Listed Building Consent for Alterations, Extension or Demolition of a Listed Building

Development: Listed building consent to form a new vehicular access following the removal of a 900mm wide gate, widening the entrance to 2.3m and demolishing 1.4m of flint wall.

Location: 11 Yew Tree Cottage Ferring Street Ferring BN12 5HL

PROPOSED NEW ENTRANCE & DRIVE TO YEW TREE COTTAGE, FERRING ST. BN12 5HL

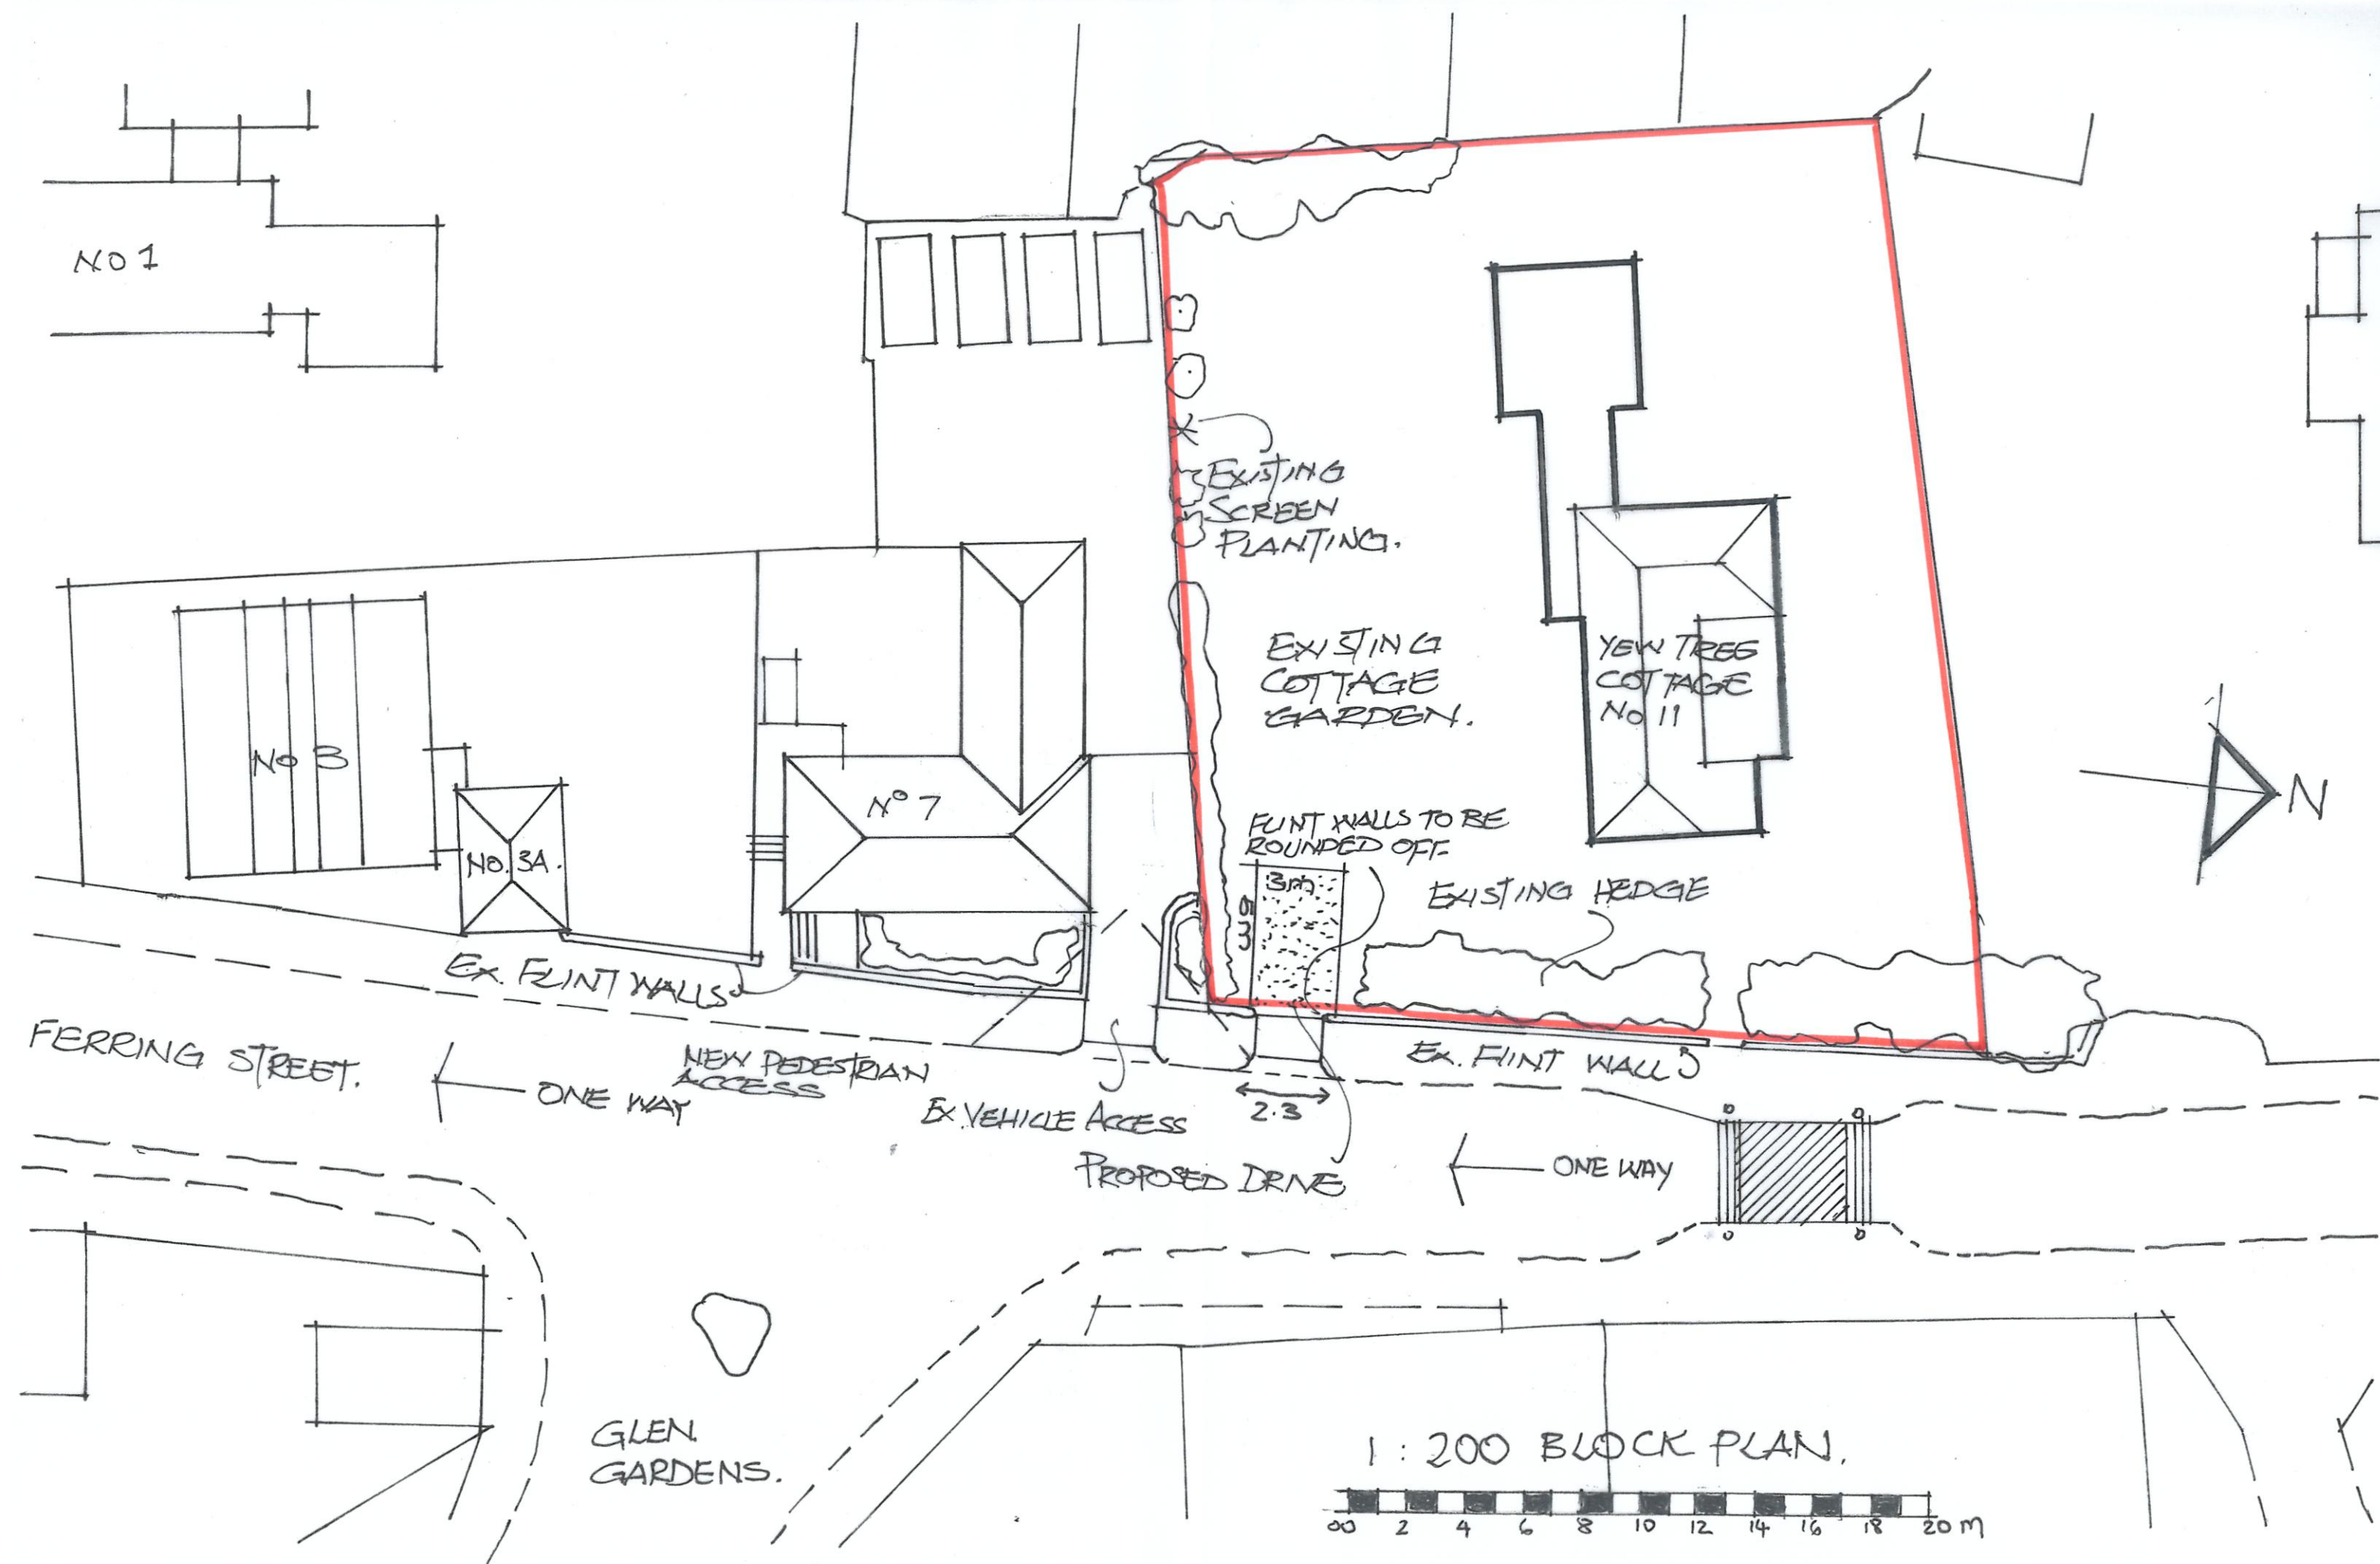
Visibility Splay

West Sussex County Council require that a visibility splay is provided. A splay is formed for a 30 mph speed limit road by measuring from a point 2.4m back from the kerb edge in the centre of the proposed access. A line should then be drawn from either side of this point for 43 m in each direction to the nearside edge of the carriage way. The splays must intersect and only within the control of the applicant, or within the publicly maintained highway.

The distance will increase with the speed limit of the road. If the road is 40 mph speed limit then the distance should be 120 m either side. For speeds above this please contact West Sussex County Council Highways for advice on what would be acceptable.

Proposed Crossover

Please provide measurements of the proposed dropped kerb (widths across the entrance to the property and the road edge, and the depth across the pavement).

PROPOSED NEW ENTRANCE & DRIVE TO YEW TREE COTTAGE, FERRING ST. BN12 5HL
 DRWG. NO. 11/01 JULY 2025

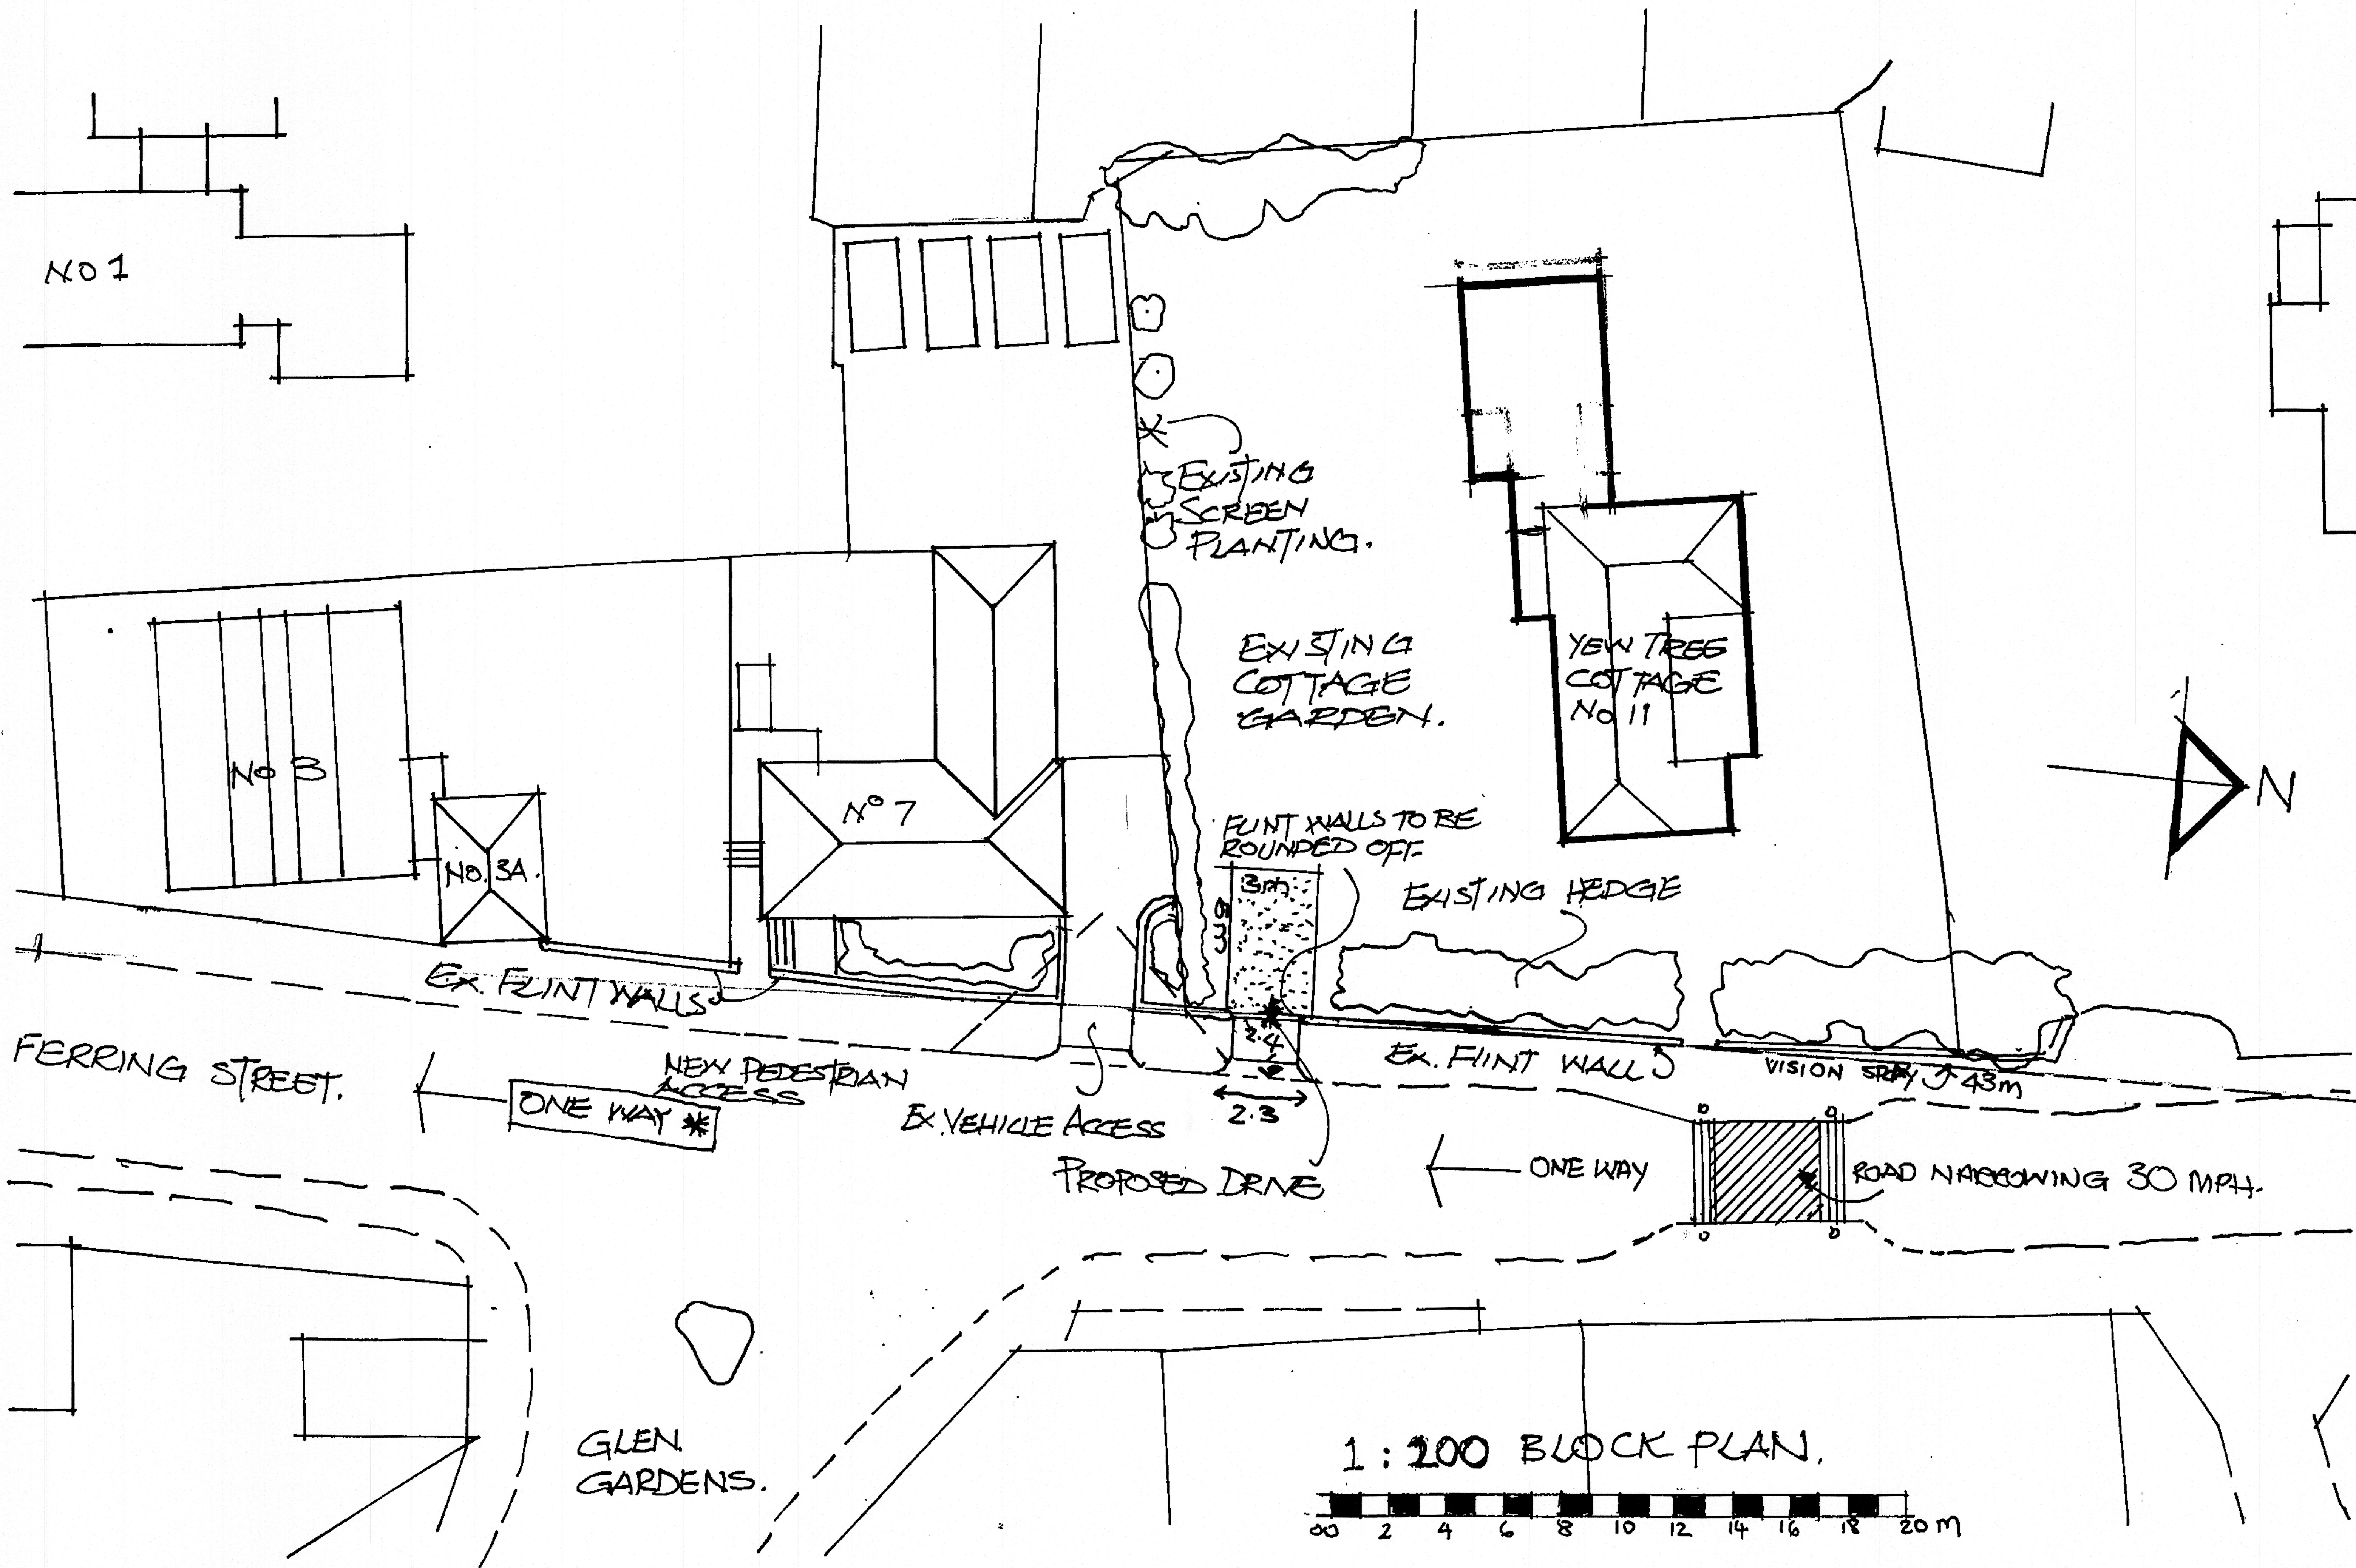
Elevations

Please submit electronic plans in pdf format clearly labelled existing and proposed elevations at a scale of 1:50 or 1:100. Further details can be found in the Validation Requirements List.

Existing Plans

Please submit electronic plans in pdf format clearly labelled existing plans at a scale of 1:50 or 1:100. Further details can be found in the Validation Requirements List.
